Officers Report

RE: Conversion of extended property into 2 no residential flats

SITE: 28 STATION APPROACH SOUTH RUISLIP MIDDLESEX

I refer to your request for pre-application planning advice dated 23.01.23 and our subsequent meeting on 20.03.23 relating to the above development. The advice provided is based on the following drawings and documents issued to the Local Planning Authority for consideration:

Proposed layout

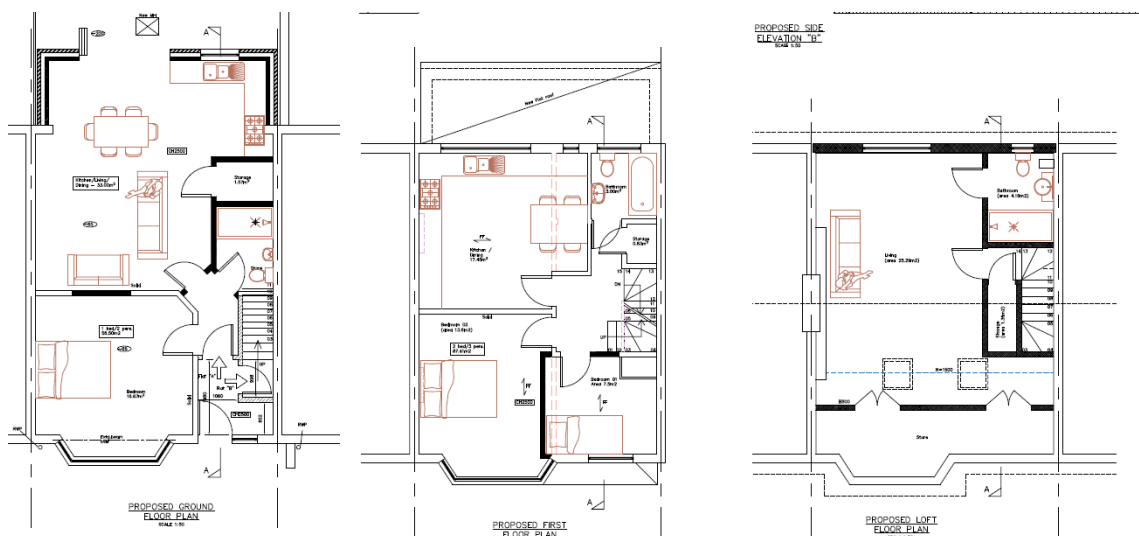
However, the paraphernalia required to accommodate two units on site do need to be carefully considered. This would involve the provision of vehicle parking, cycle stores and refuse and recycling storage. The submitted drawing shows the provision of three ad hoc parking spaces in the front garden (which raise questions with manoeuvrability), as well as refuse storage provision and cycle parking. Given that the site is mid-terrace the proposed cycle storage for the ground floor flat would raises concerns with its functionality, since it would be inconvenient for occupants to wheel their cycles through the flat. Therefore it is more likely that cycle parking would need to be accommodated. However this would need to be balanced with ensuring that the front garden is not cluttered and visually obtrusive within the street scene. Care would need to be given to this when submitted a proposal for planning permission.

The local plan permits a maximum 1.5 - 1 car space per 1-2 bedroom flat. Therefore 2 car parking spaces would be acceptable for the proposal and this reduction would reduce the appearance of clutter in the front garden. The introduction of soft landscaping would also assist in ameliorating the appearance of clutter, and should be considered in any future planning application. Details of the scale and appearance of any refuse storage and cycle parking enclosures should also be submitted with any planning application.

Both of the proposed flats appear at face value to exceed these minimum internal space standards and have adequate sized rooms. However based on the submitted section it does not appear that there is sufficient floor to ceiling heights of at least 2.5m. This would need to be considered.

It is noted that cars are proposed to be parked in front of the bedroom window of the ground floor flat. Defensible soft landscaped garden space should be incorporated to ameliorate any perceived or real loss of privacy and disturbance.

The submitted drawings state that the existing rear garden, which provides approximately 42sqm of private outdoor amenity space, would be for the use of the 1 x 1 bed ground floor flat. The 1 x 2 bed first floor flat would not have any private outdoor amenity space, which would be contrary to the requirements of Policy DMHB 18 of the Hillingdon Local Plan: Part Two - Development Management Policies (2020) and would not be supported by the Council. Balconies or terraces for the upper floor flat would not be appropriate, and would be out-of-character with the area.

The submitted drawings indicate that 3 off-street car parking spaces would be provided on the site frontage area. On that basis, the number of car parking spaces should not be an issue. However, there are concerns with manoeuvrability. This can be reduced to 2 off-street car parking spaces which would still comply with policy but enable more effective vehicle tracking. In respect to amenity it would also provide better opportunities for improved soft landscaping and the sensitive provision of refuse storage and cycle parking. An electric vehicle charging point should be provided to meet current policy requirements.
